KIRKLEES METROPOLITAN COUNCIL INVESTMENT & REGENERATION SERVICE

DELEGATED DECISION TO DETERMINE APPLICATIONS FOR LISTED BUILDING CONSENT

Reference No:	2023/65/91971/W
Site Address:	114A, Fitzwilliam Street, Huddersfield, HD1 5PH
Description:	Listed Building Consent for Change of use, alterations, part demolition of boundary wall and erection of two storey side extension to convert from hot food takeaway to residential (within a Conservation Area)
Recommending Officer:	William Simcock

Officer Report 2023/91971

Drawing
Existing Elevations

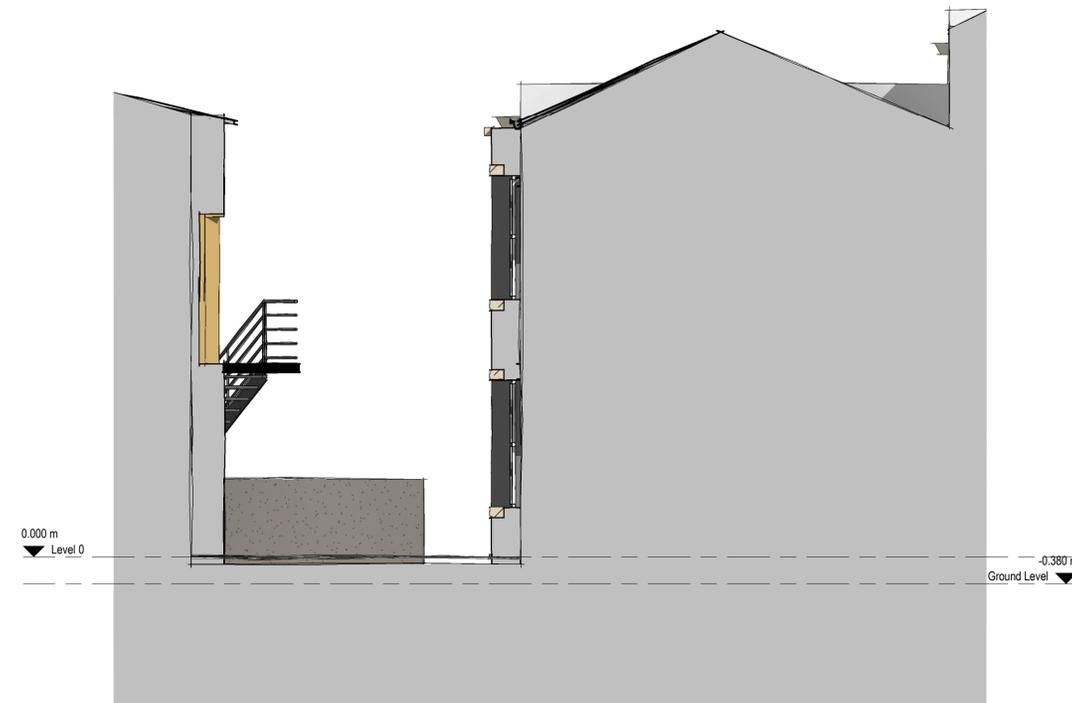
The principal elevation is finished in the finer ashlar stone whereas the side elevation is finished in hammer-dressed stone. The elevation does still have details of note, including original window and door openings and stone corbel gutter hangers. The elevation has always been exposed and prominent and there is no historic evidence to show that there has ever been any structure in this location.

Despite having been reduced in size from the previous proposal, the proposed extension would enhance or better reveal the significance of the building. The extension itself, and the loss or obscuring of the historic fabric (including the ground floor window openings) would undermine its character and significance. It has not been demonstrated either that the present use is unviable or that it would be impossible to adapt or repurpose the building without extension or significant alteration. Whilst the harm to the significance of this heritage asset is judged to be “less than substantial” within the meaning of the NPPF, even less than substantial harm must be justified by a proportionate public benefit. Here, there is no justification for the proposal because there is no demonstrable public benefit that would outweigh the harm caused.

1. The proposed development, owing to the scale and siting of the proposed extension, and by its resulting in the loss or obscuring of original architectural features in the side elevation, would undermine the character and significance of the Listed Building. The degree of harm caused is deemed less than substantial within the meaning of the National Planning Policy Framework (NPPF), but it is considered that no public benefit has been demonstrated that would outweigh the harm caused in this instance. The proposals therefore do not accord with Policy LP35 of the Kirklees Local Plan, Chapter 16 (paragraphs 205 and 208) of the NPPF and would be incompatible with the Council's duties under the Planning (Listed Building and Conservation Areas) Act.

Drawing  
Proposed Floor Plans

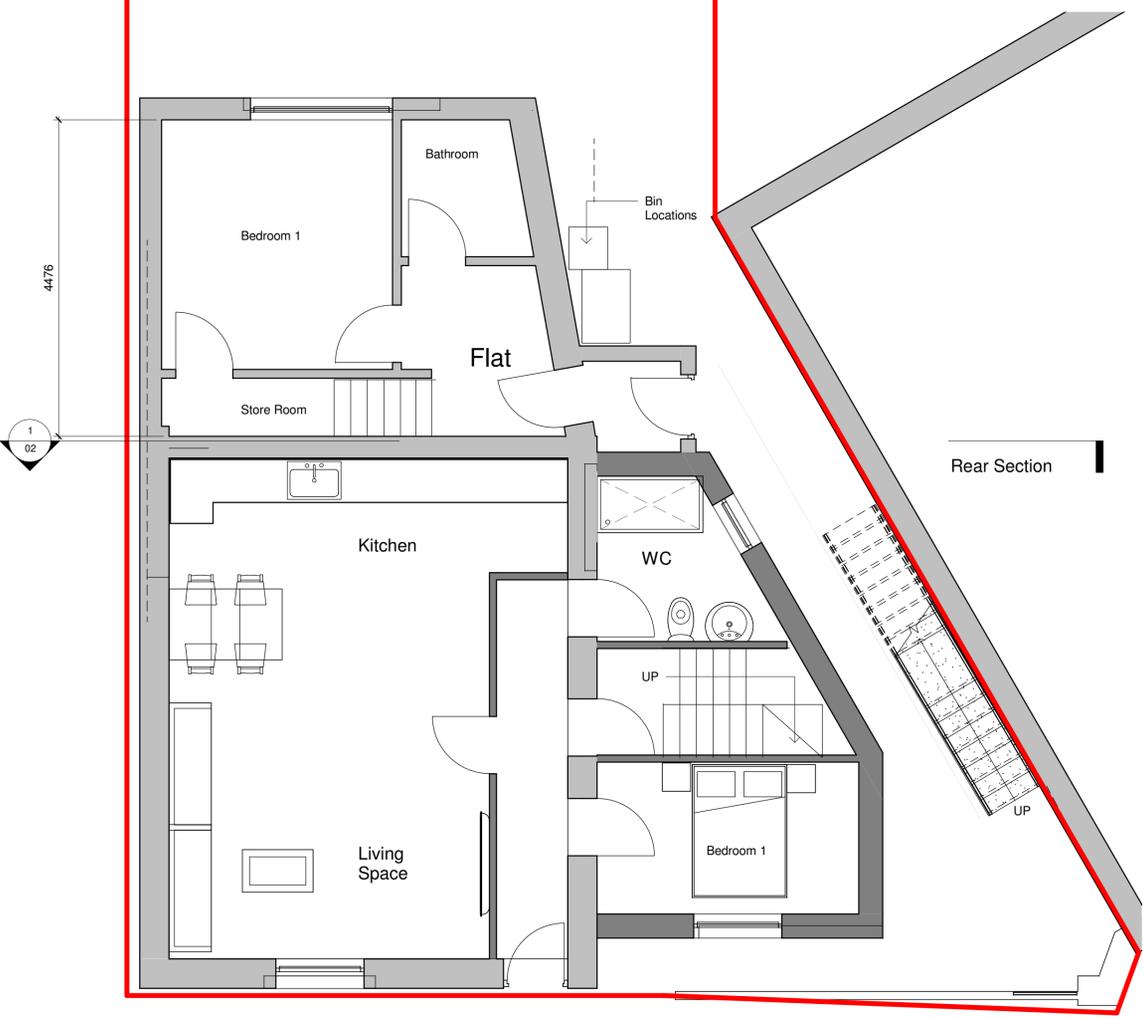
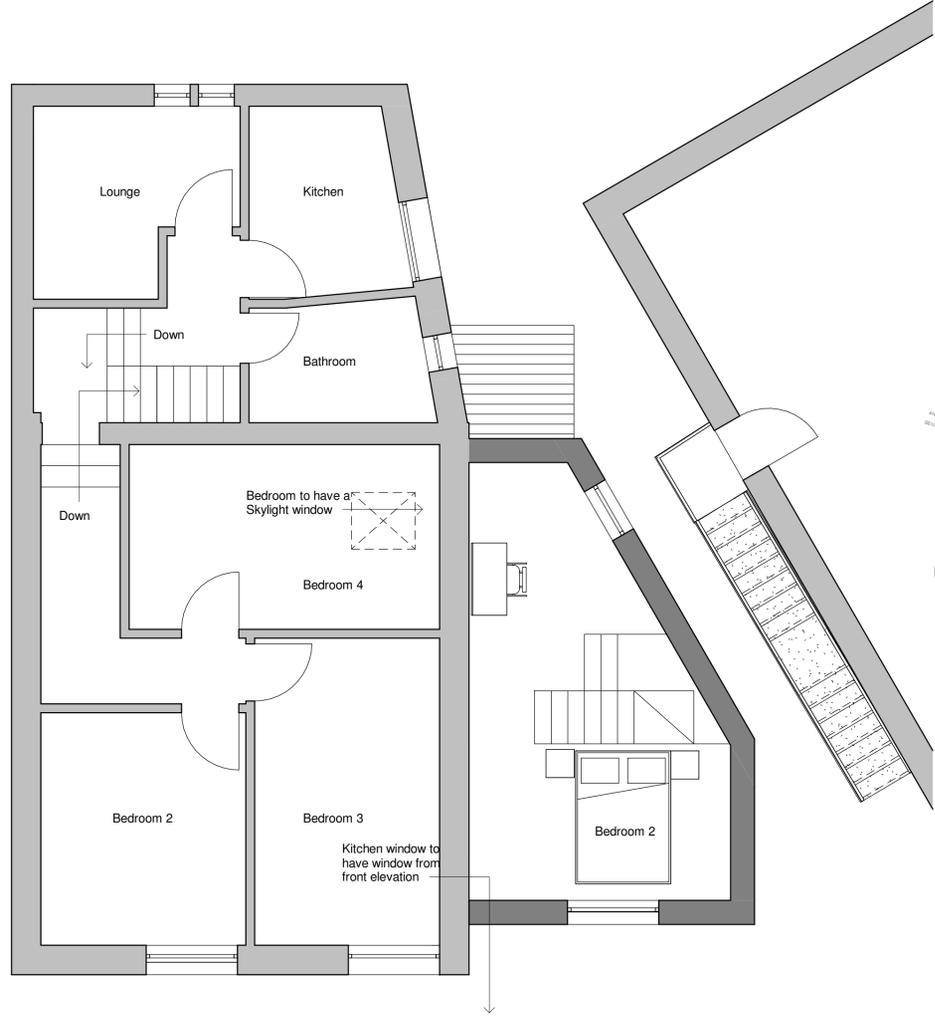
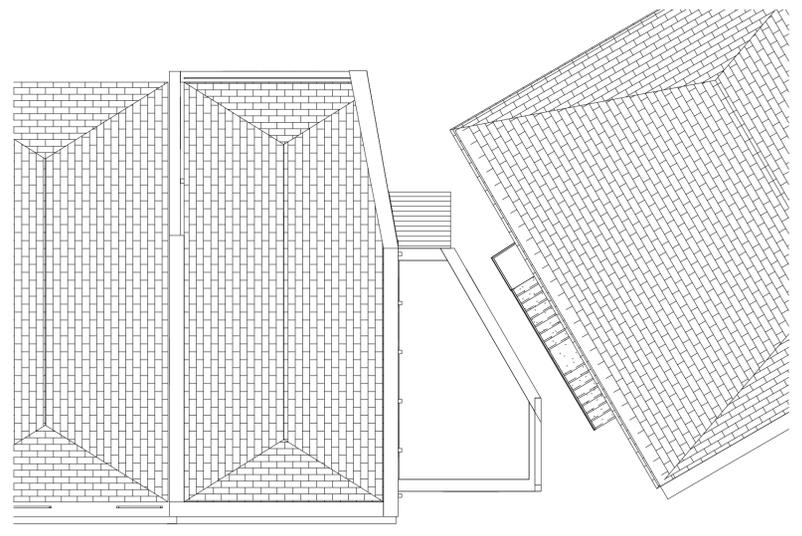
The side extension would be a maximum of 4.0m in width, the first part of the side elevation built parallel to the existing side wall but then tapering into a width of 1.6m at the rear. It would be set in from the existing front wall by 650mm and would have a flat roof with a parapet.

One windows at ground floor would be blocked up completely, one adapted to form an internal door (all in the eastern elevation). Internally, there would be some re-partitioning of the internal space.
